Your Ref: OWPC21315
Our Ref: M/153/18/PL 13-12-2018
Please ask for:
Mrs A Gardner

1 No. dwelling with detached garage (amendment following M/7/16/PL)

Land adjacent to 46 Sea Lane Middleton-On-Sea

First Floor 1:100 @A3

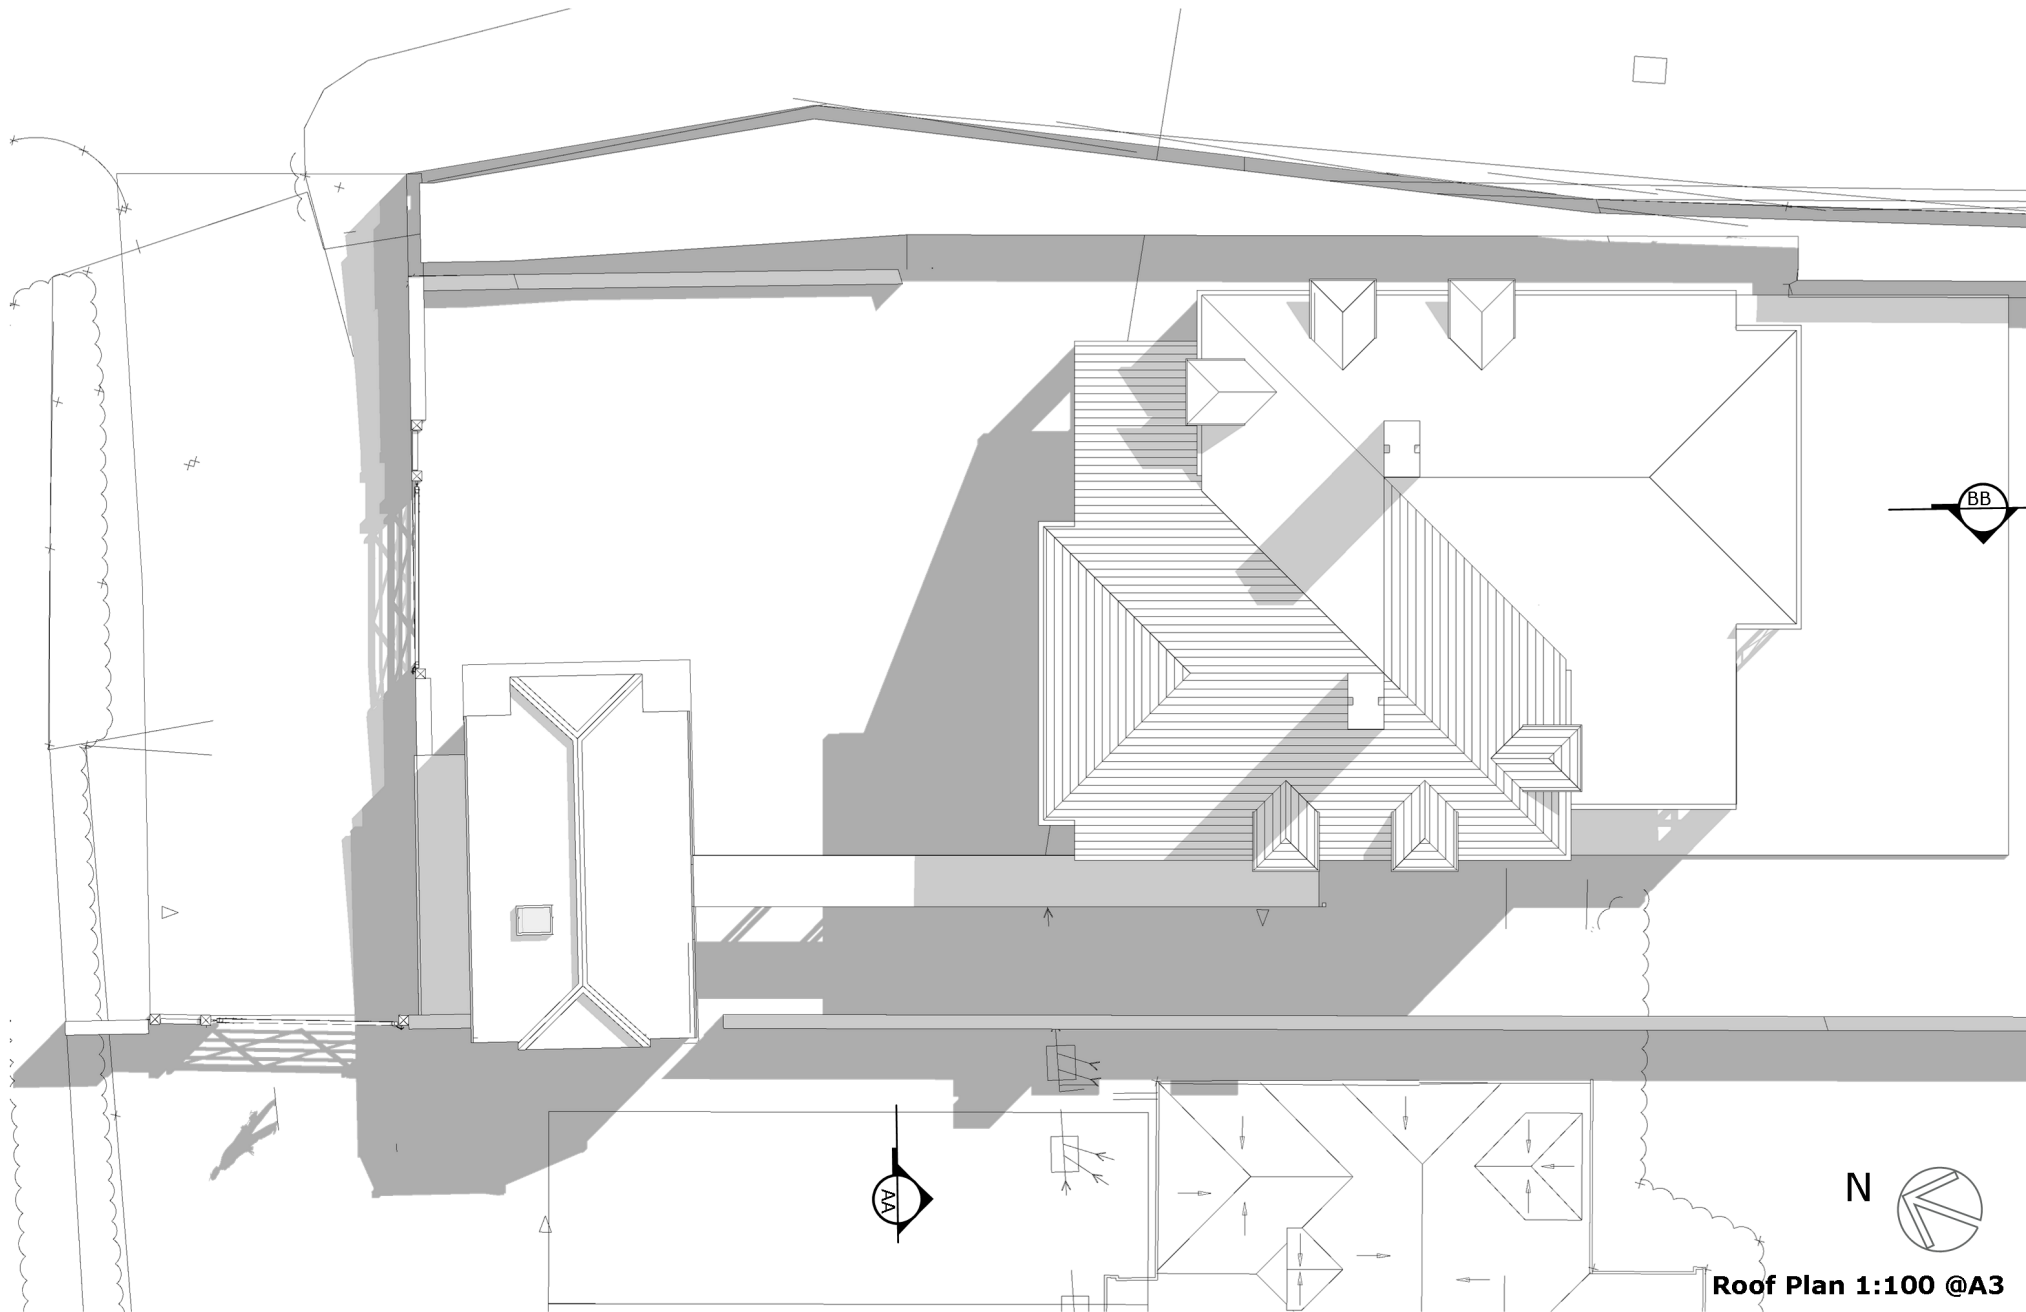
Further to the Middleton-on-Sea Association letter I would like to add that as the next door neighbors of the 46a Sea Lane our garden will be overlooked from the proposed first floor balcony of the house. (This is in addition to the fact that we'll be overlooked by the first floor window of the garage, which we already objected to during the previous consultation M/7/16/PL).
